Stockton Sand Quarry Dredging; DA SSD-9490

DPIE internal review of Social Impact Assessment

Compiled by Richard Parsons, April 2020

This review considers the SIA Report (November 2019) for Stockton Sand Quarry Dredging, prepared by Element Environment on behalf of Boral Resources (NSW) Pty Ltd. The Development Application is for continued and expanded operations.

Figure 12
Social infrastructure

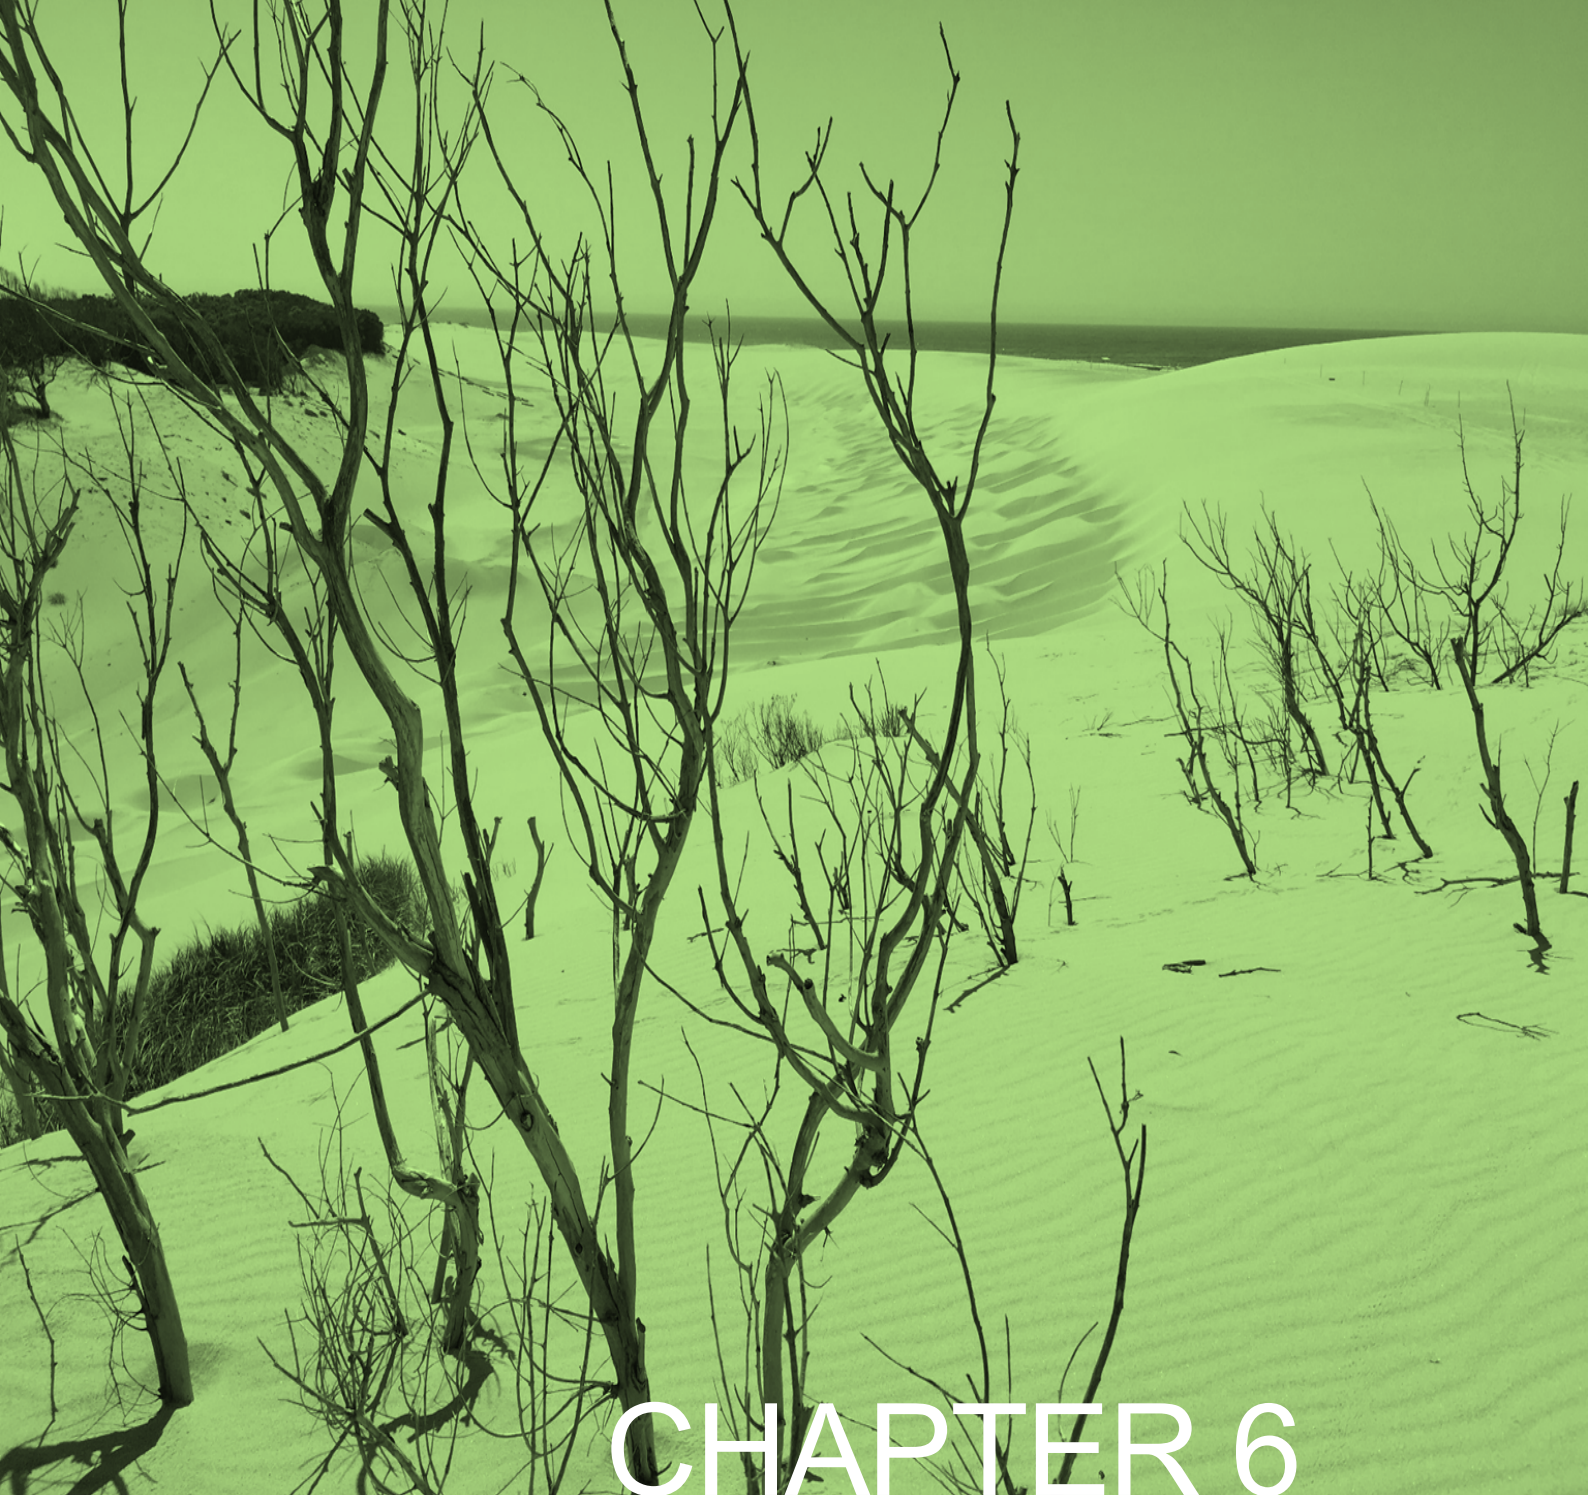
Recommendation 5: Please revise the social baseline in accordance with the guideline, to help build a picture of what people value about the locality, including any diversity in values among different groups. This could be supported by mapping any valued features on Figure 12 (p.73).
